CITY OF ALBUQUERQUE

August 9, 2024

Re: Mercado el Milagro Bldg. D
10000 Central Ave. SW
30-Day Temporary Certificate of Occupancy
Transportation Development Final Inspection
Architect's Stamp dated 07-08-21 (L09-D042A)
Certification dated 07-29-24

SITE PLAN

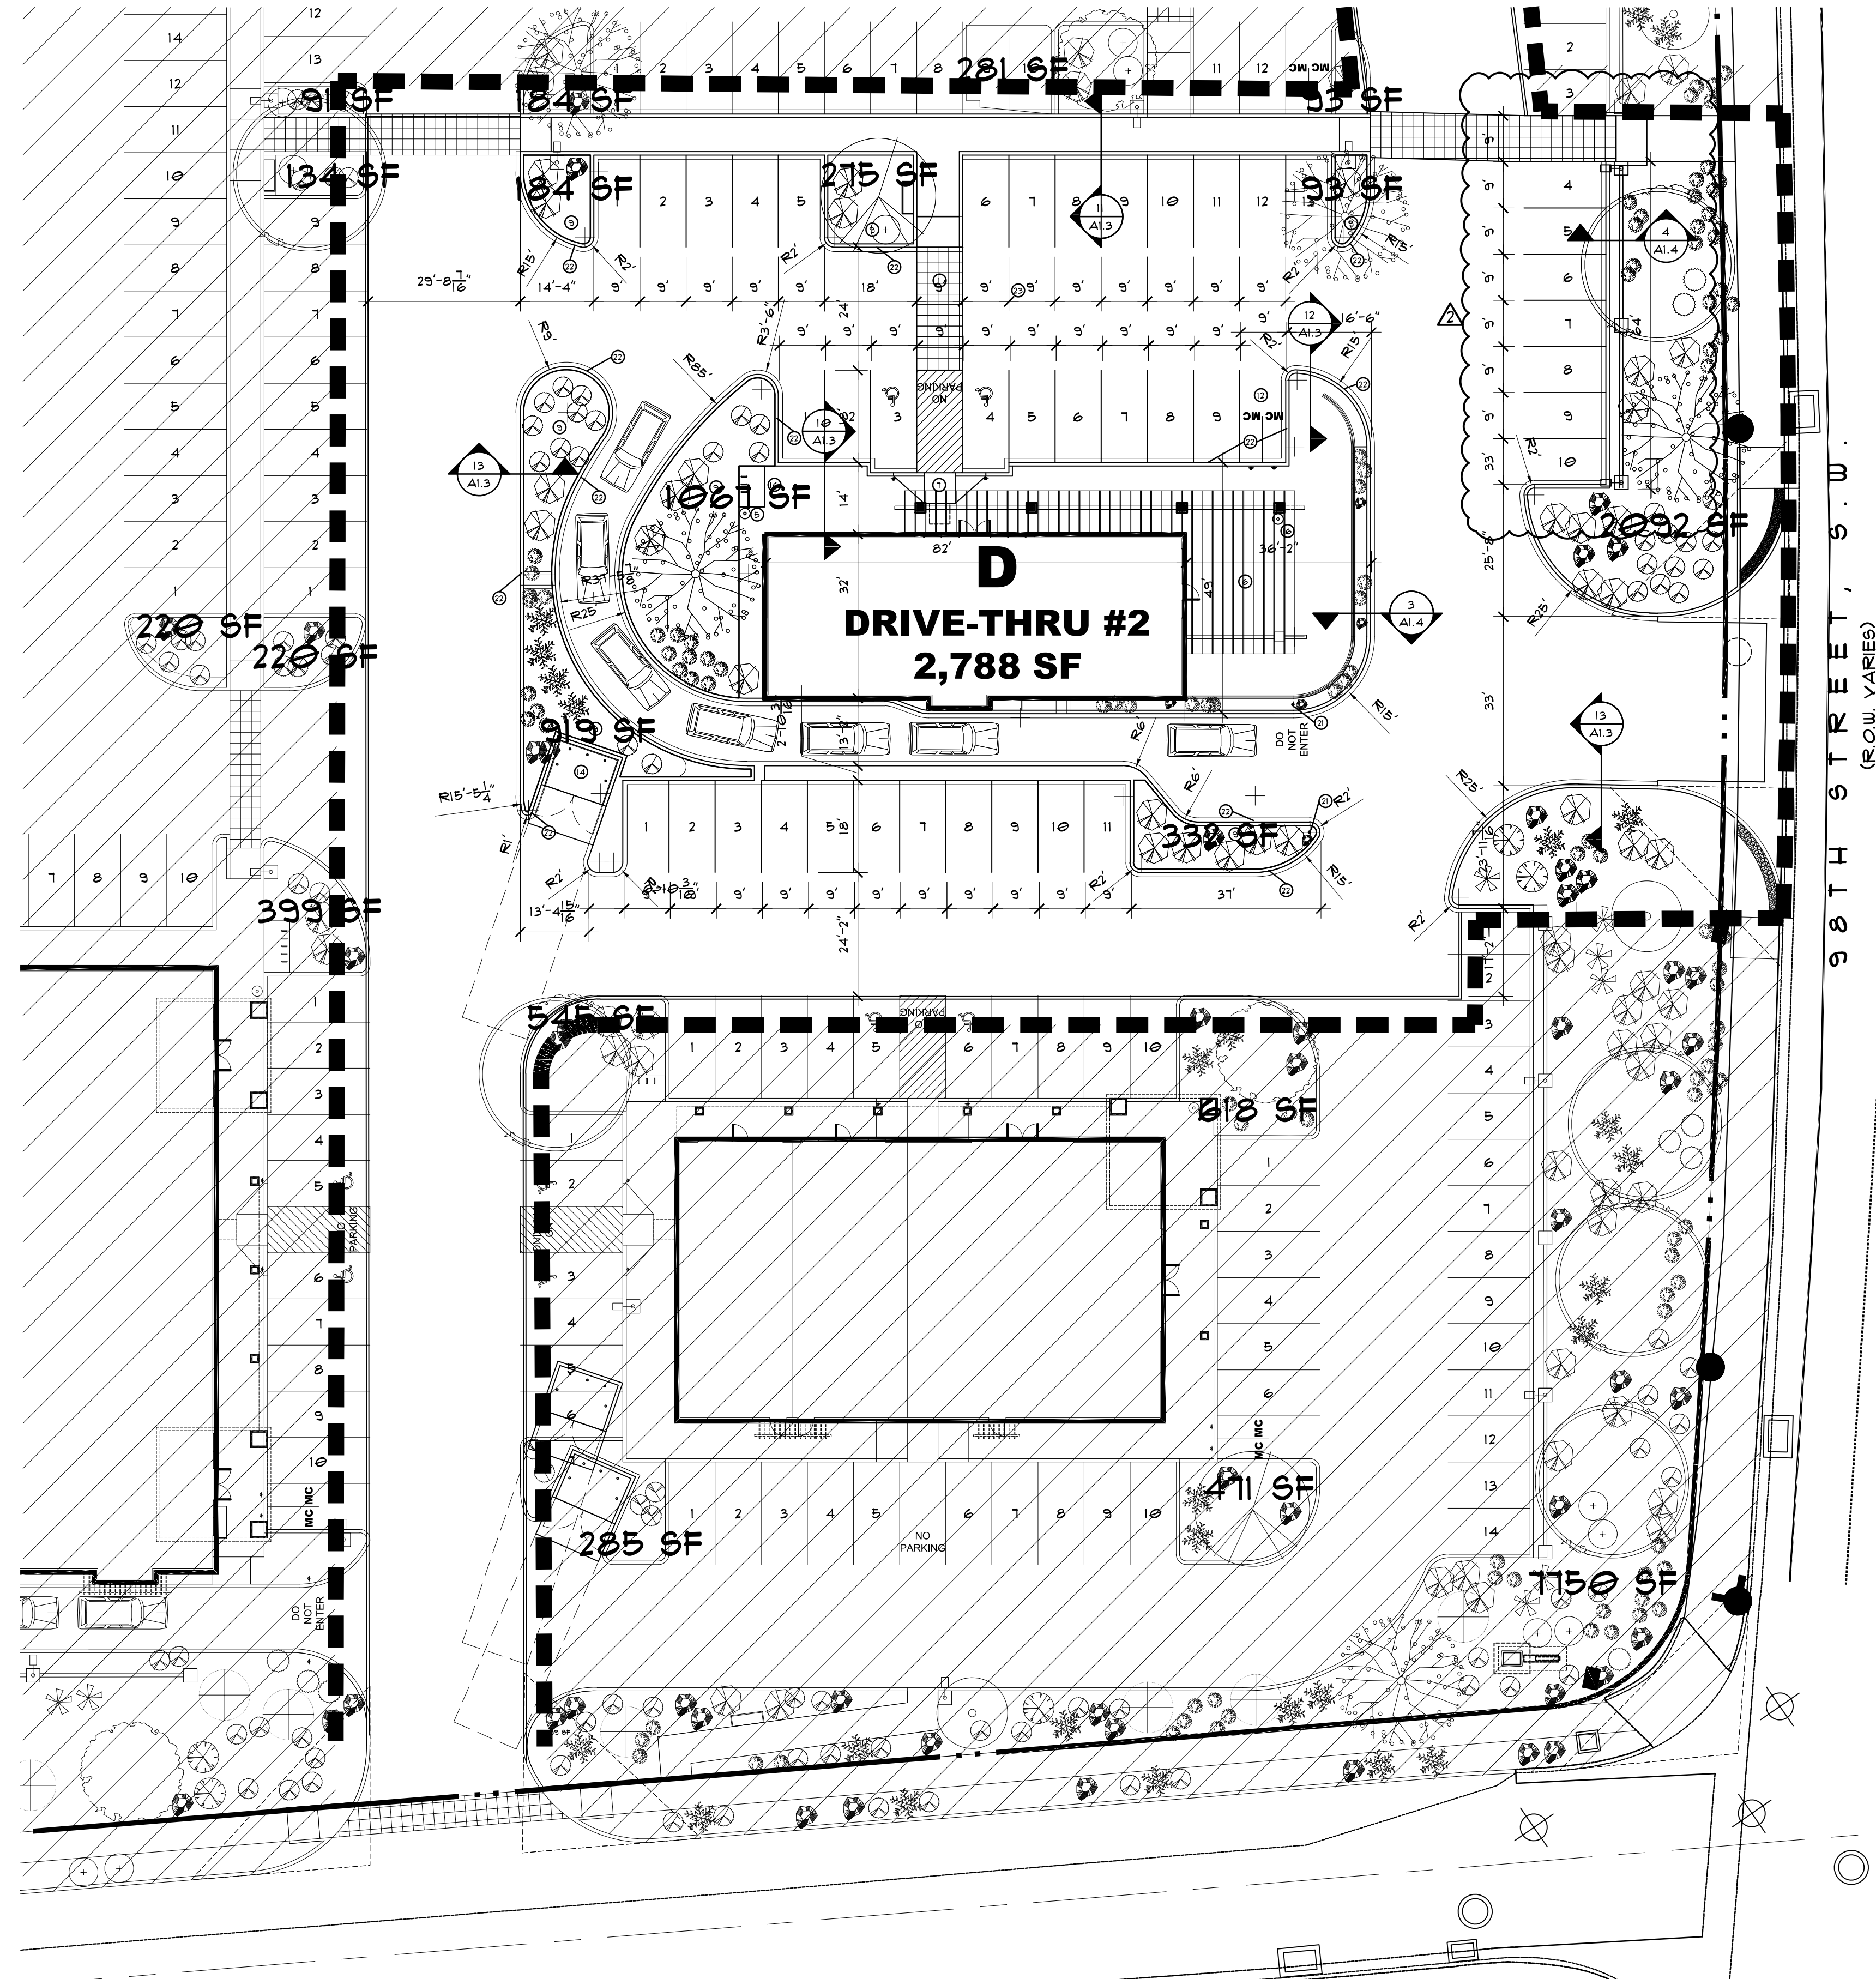
- The ADA ramp at the northeast side of the site must have a minimum 4 ft X 4 ft level landing. The running and the cross slopes of the landing shall not exceed 2% to ensure the ADA compliance. Please reconstruct this ramp to ensure it meets the necessary standard.

- Per approved plan, please provide "DO NOT ENTER" pavement marking at the exit of the drive-thru lane, and "MC" pavement marking on the Motorcycle parking spaces.
